Date: 17th April 2014

Your Ref: WSCC/096/13/F
Our Ref: TE1093_170414RS

NEW CIRCULAR TECHNOLOGY PARK – FORD AIRFIELD – RESPONSE TO ADDITIONAL HIGHWAY COMMENTS

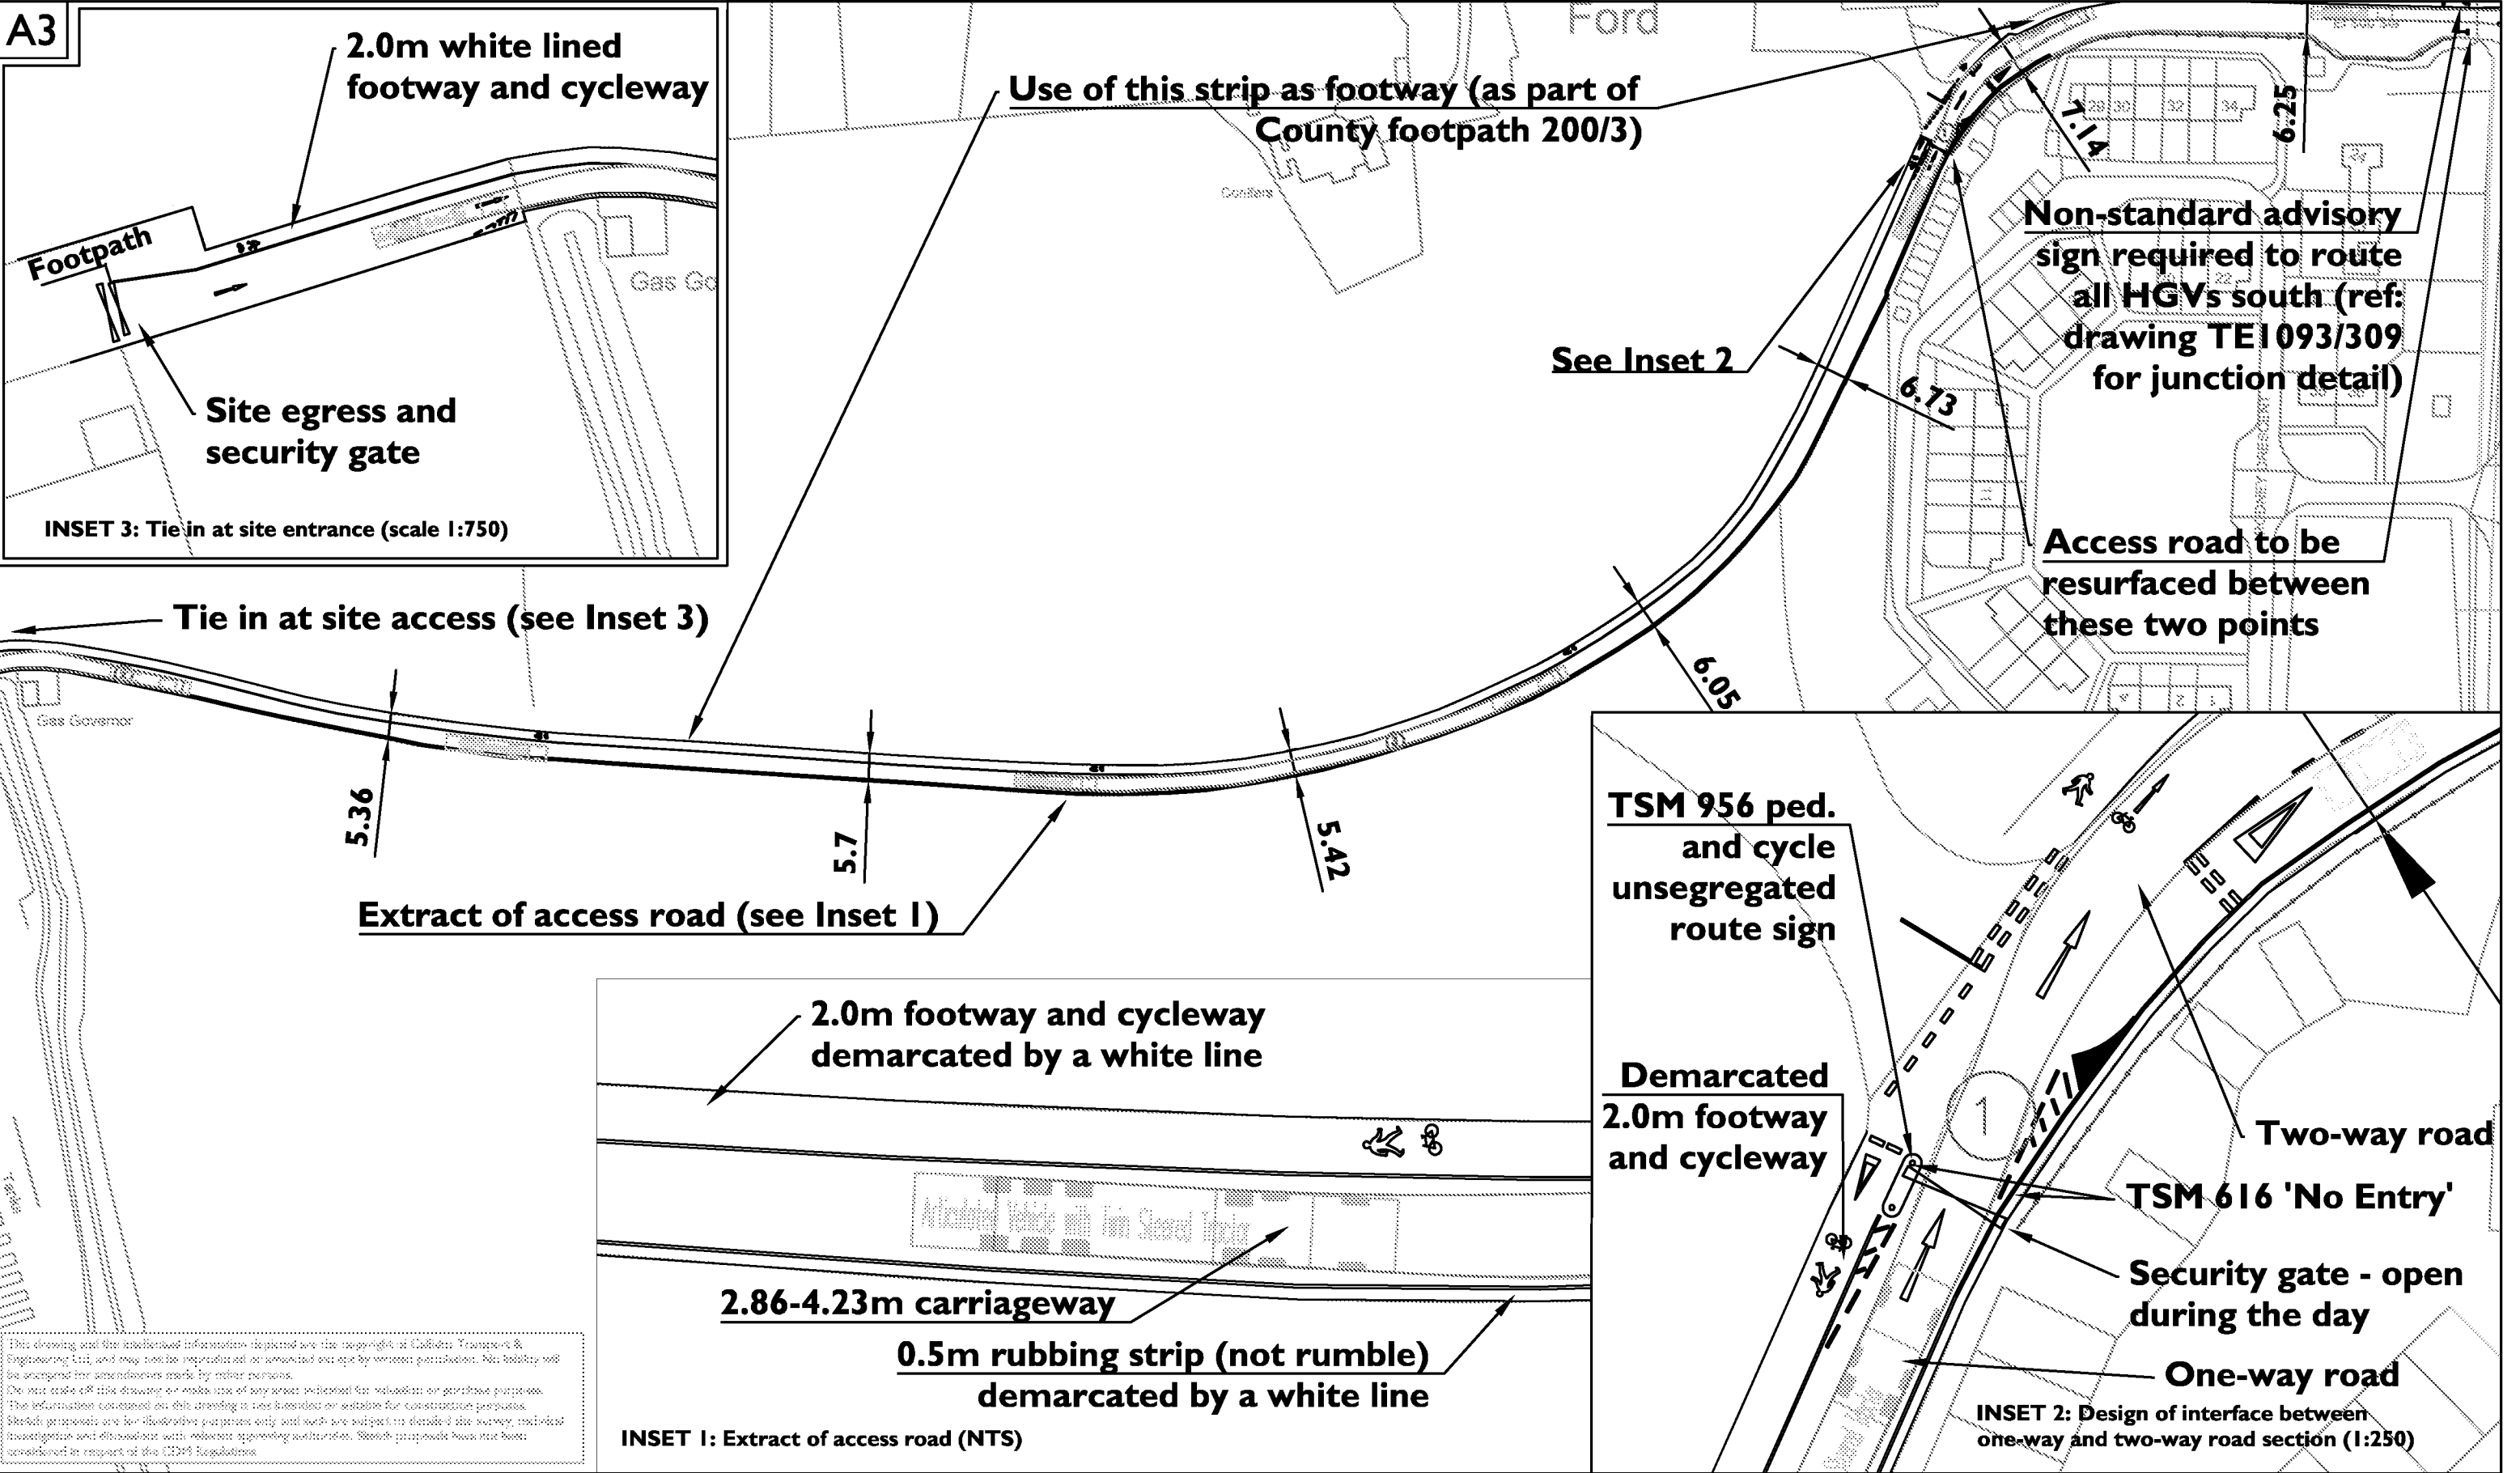
Forward visibility on the approach to the Studio access has been assessed (see drawing 308D attached). A westbound vehicle waiting at the give-way line to turn into the Studio access will have a forward visibility of 32m. The stopping sight distance (SSD) requirement in Manual for Streets for a 20mph road is 25m. This is the distance over which a driver needs to be able to see in order to stop from a given speed. Therefore, there is adequate forward visibility at this location to enable a driver to see an approaching truck and for a truck to stop if necessary.

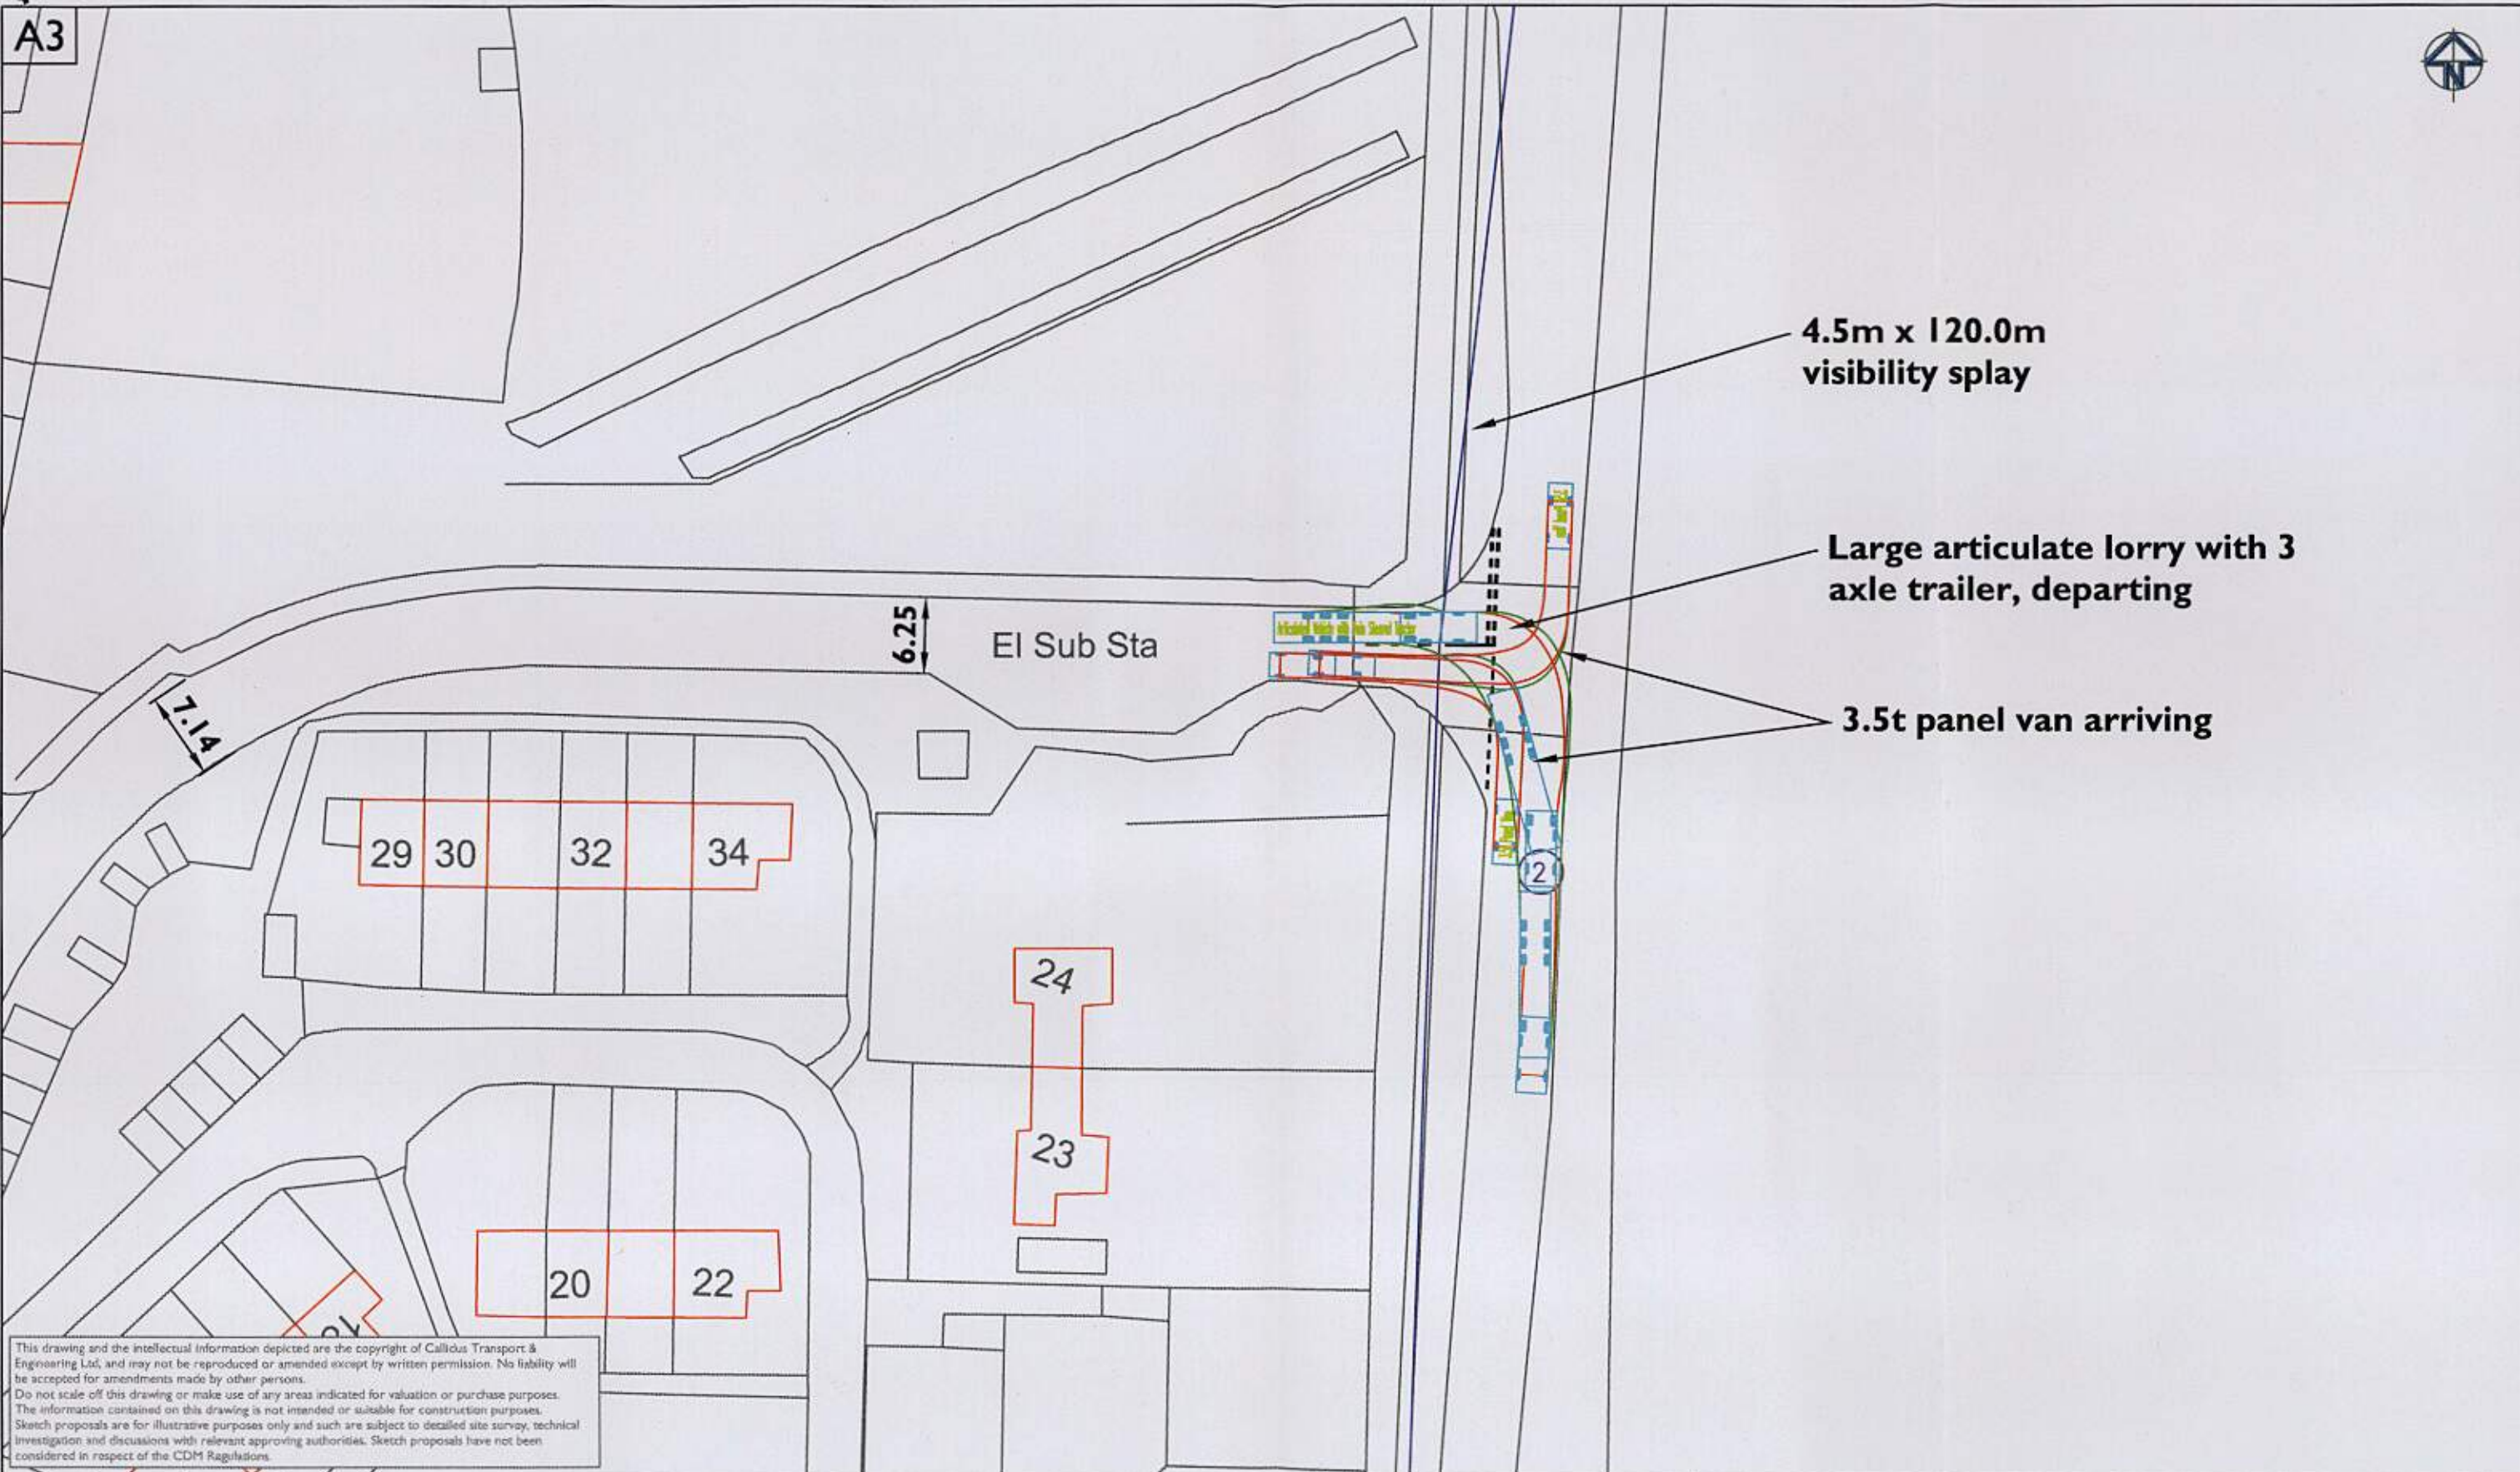
A truck that departs from the eastern access junction from a stationary position at the give-way line will do so such that the trailer of the truck will overrun the inbound lane of the access road. This is shown in the attached drawing 301C. This is not an unusual situation and at a lightly trafficked junction such as this, this will not represent any difficulties. The very low volume of vehicles turning in and the forecast 6 trucks turning out per hour, means that the likelihood of vehicles arriving and departing at the same time will be very low.

If a vehicle does arrive at the same time that a truck wants to depart, there will be no conflict between the vehicle manoeuvres if the departing truck waits for the arriving vehicle to turn in or vice versa. The vehicle turning in has the priority and therefore it is most likely that the truck will wait.
